From: Richard Castro-Parker
Sent: 12 August 2019 14:56
To: Planning.Responses
Subject: FW: Gladwyn, The Street, East Preston
Attachments: 2386_01_02.pdf; 2386_01_03.pdf; 2386_01_05.pdf

Plans for uploading to Gladwyn EP/179/18/PL

Subject: Gladwyn, The Street, East Preston

2386/01/05

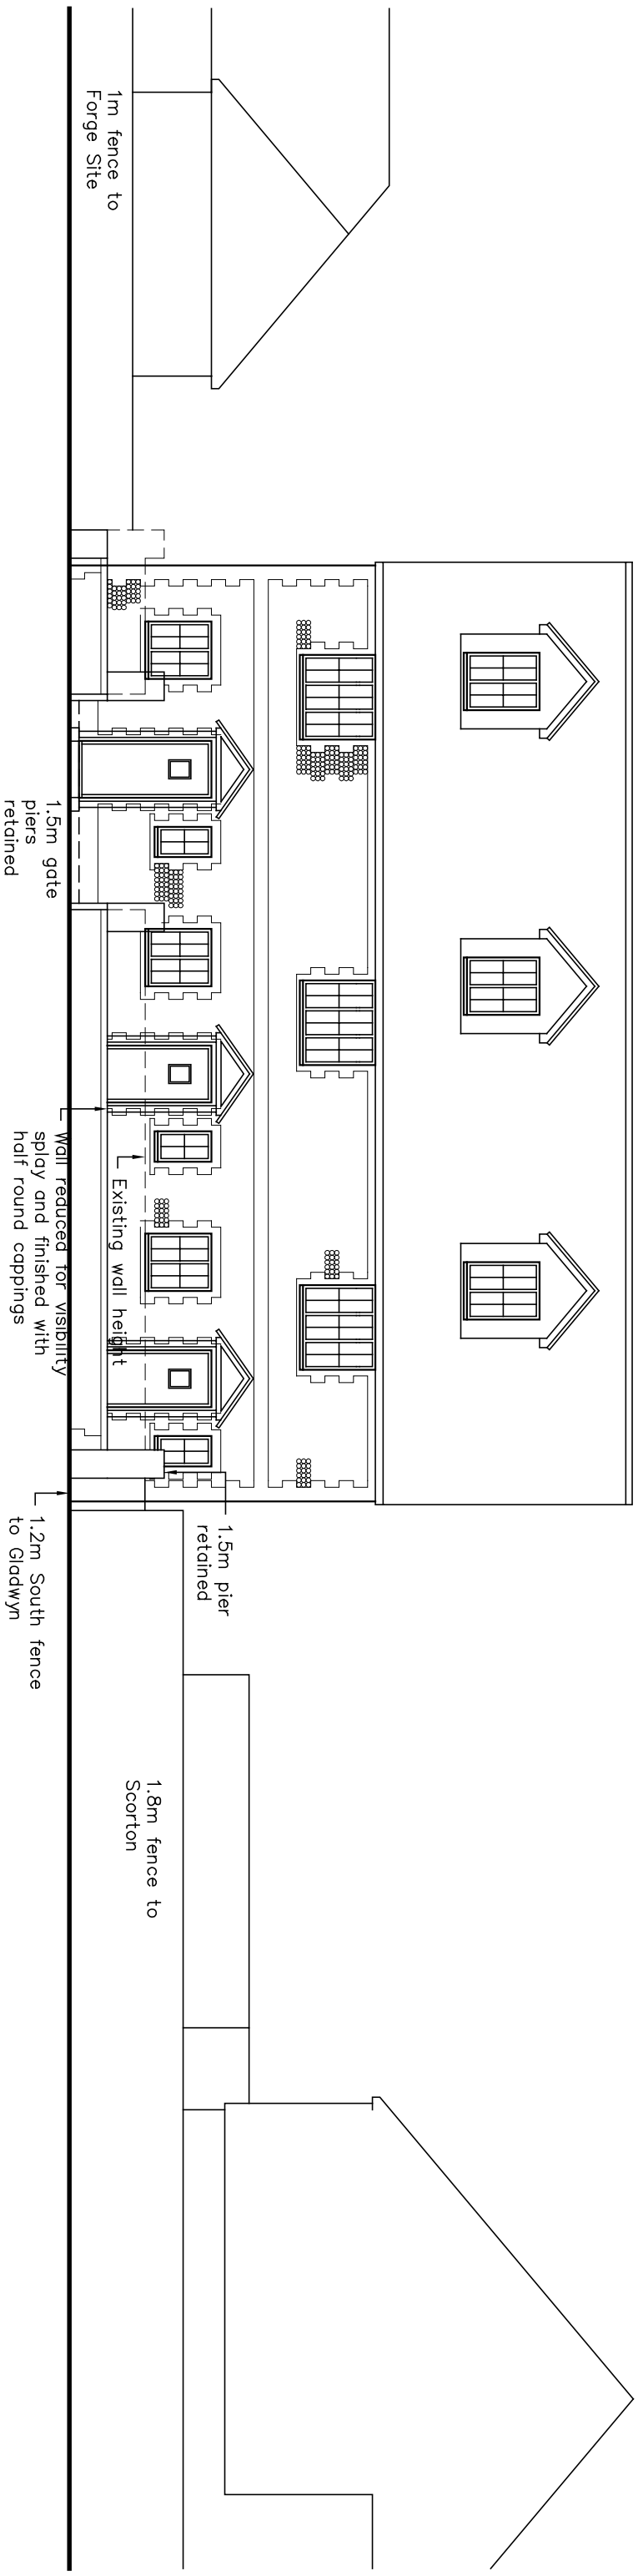
Please see the revised drawings attached and together with the new heritage statement. We believe they now address the various items that have been discussed over the elevations and frontage.

During consultation WSCC highways asked for the visibility splay and unfortunately it means the front wall has to be lowered. Half round copings are suggested to finish the wall.

Project: Proposed new homes; Gladwyn, The Street, East Preston BN16 1HT			
Drawing: Block plan, bin store elevations			
For: Mrs. J. Simmonds & Mr. P. Beamish			
Drawn: PKS		Date: November 2018	
Scales: 1:50 1:200		No: 2386/01/03/C	
To scale when printed on A3

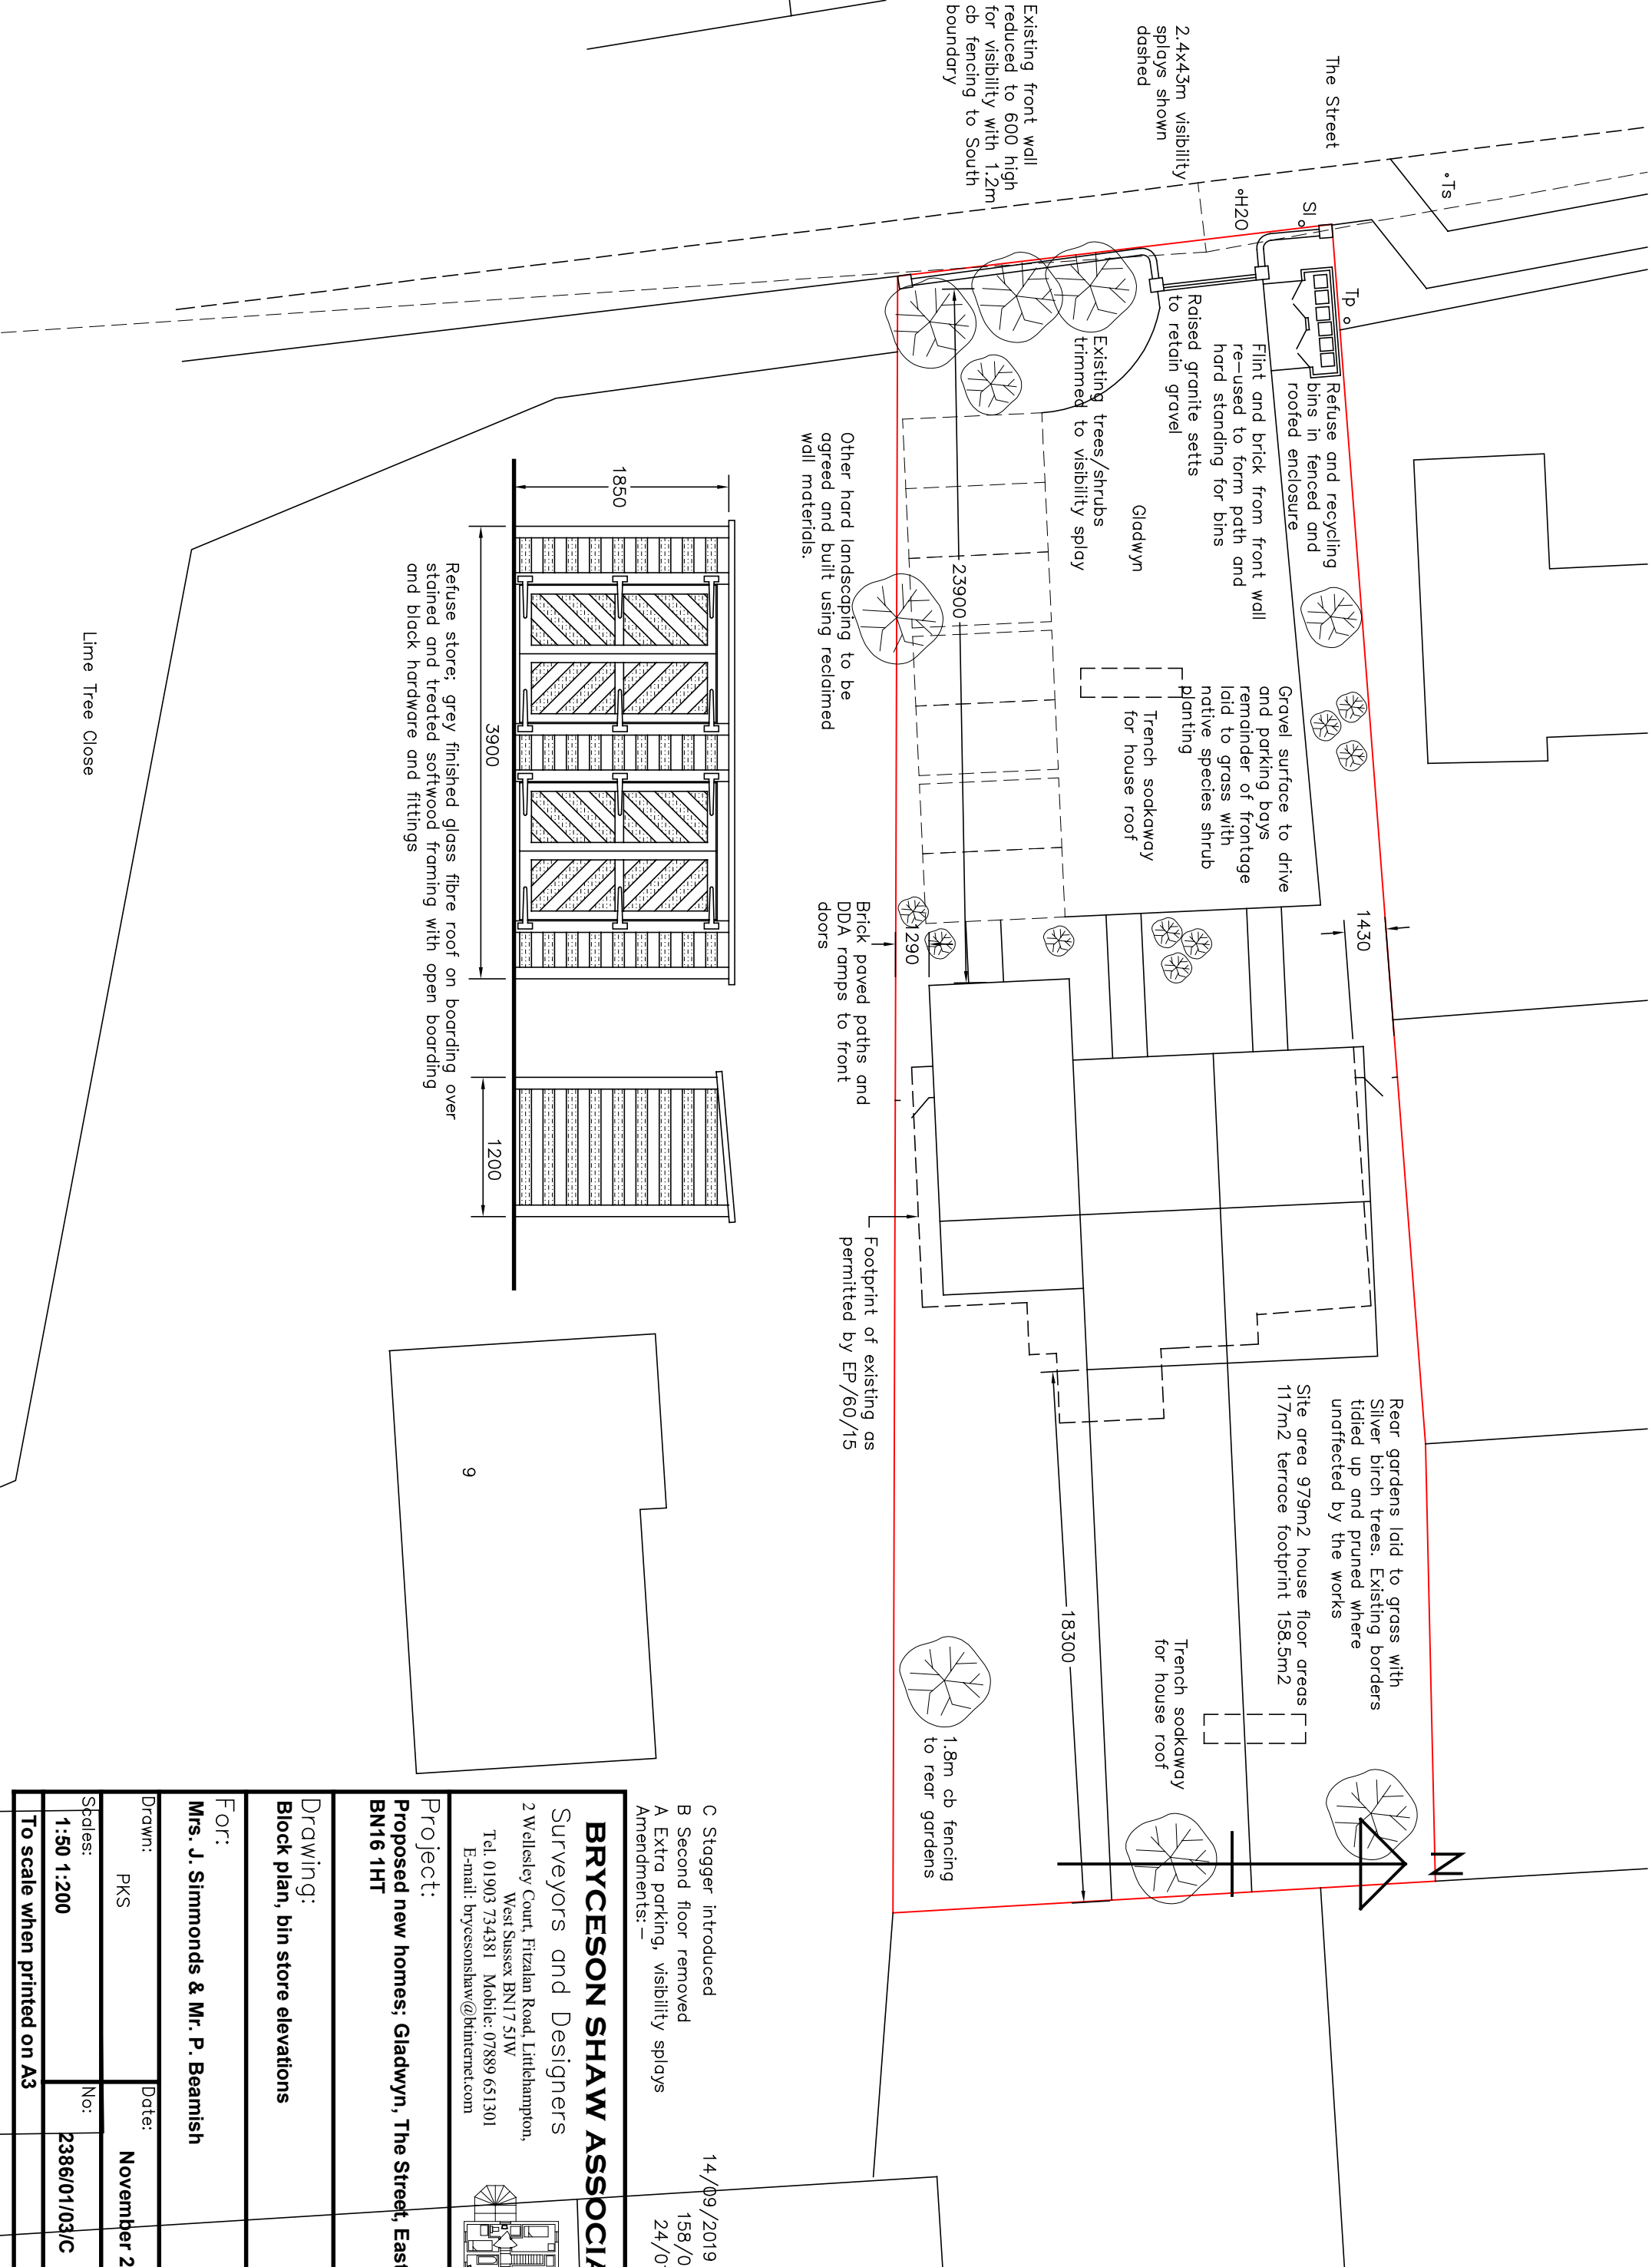
Any hard landscaping agreed upon will be built re-using the materials from the front wall.
